March 17, 2015

Re: Status of Improvement Permit Application and New Well # 15-5-35661

An attempt was made to evaluate your property for the purpose of issuing an Improvement Permit. The evaluation could not be completed for one or more of the following reasons.

REVISION
 SITE PLAN APPROVAL
 DISTRICT RA20 USE Drum
 #BEDROOMS 4
3-24-15
 Date Zoning Administrator

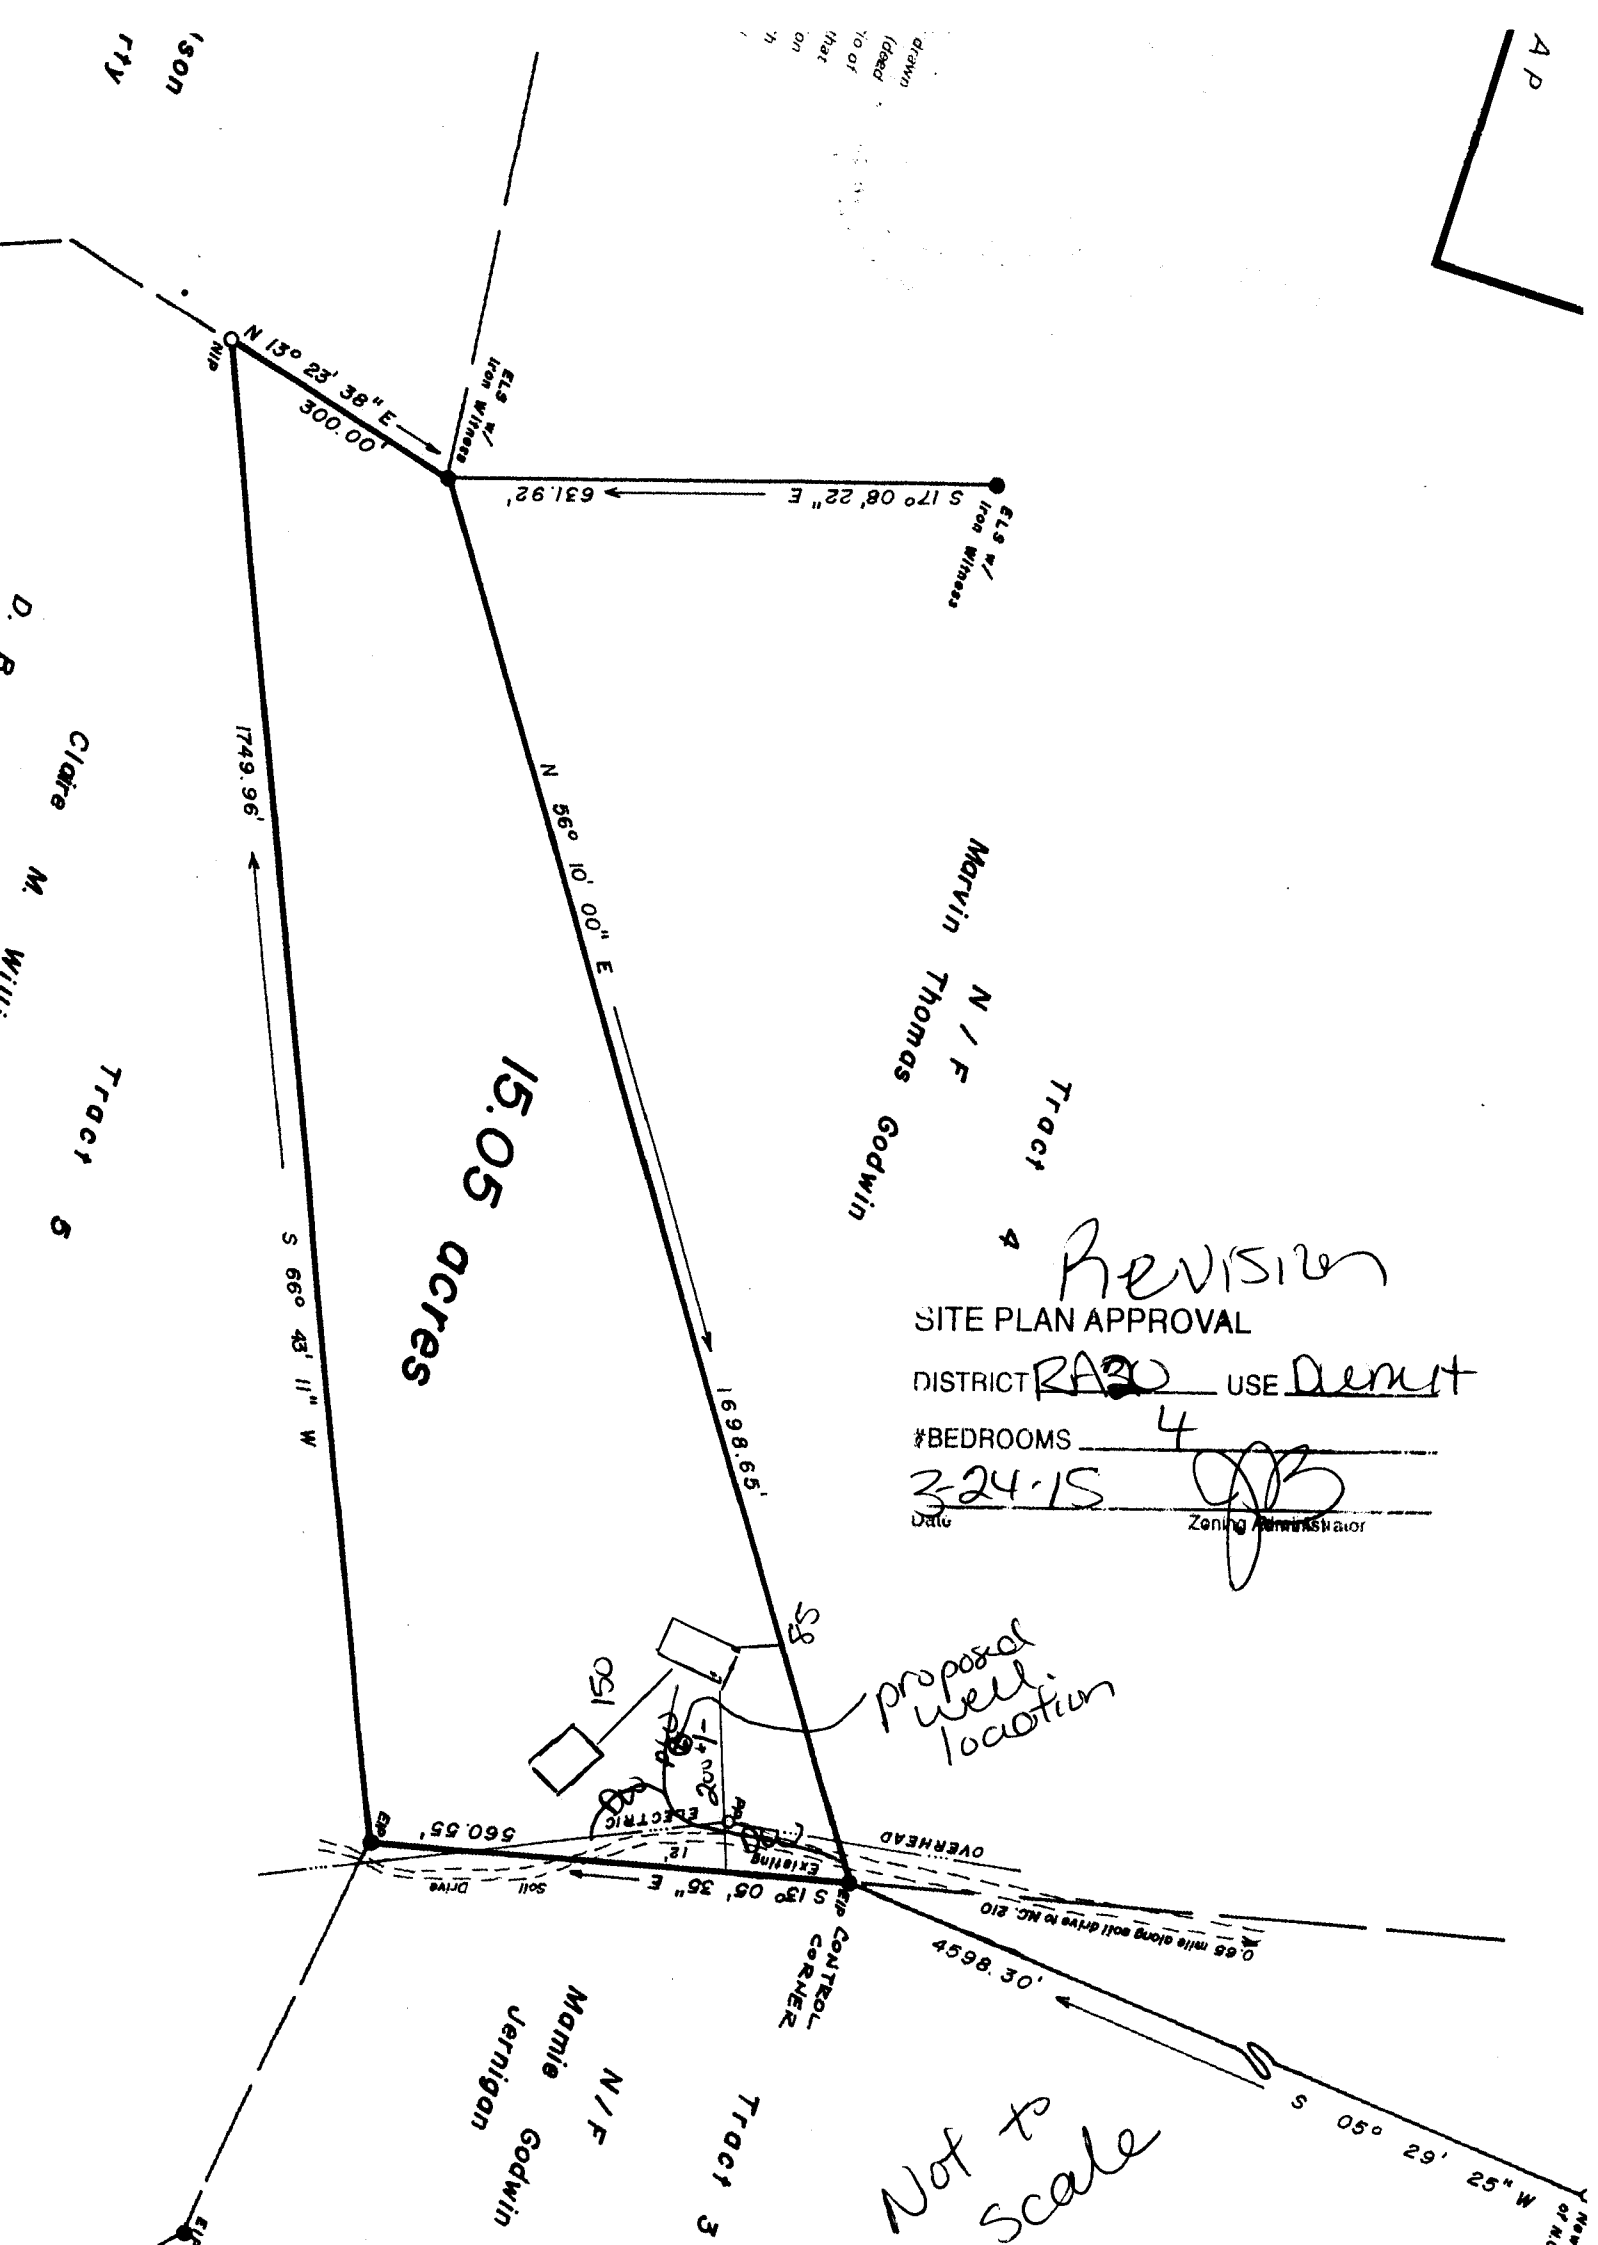
- 1. Use pink flags to mark property lines and irons that are set by surveyor need to be visible (*\$25.00 fee incurred*)
- 2. Use orange flags to mark house corners (*\$25.00 fee incurred*)
- 3. Directions not clear to property (*\$25.00 fee incurred*)
- 4. Property needs only brush or vegetation removed
- 5. Driveway not shown on site plan
- 6. Backhoe pits required
- 7. Other – Submit a copy of the recorded map.
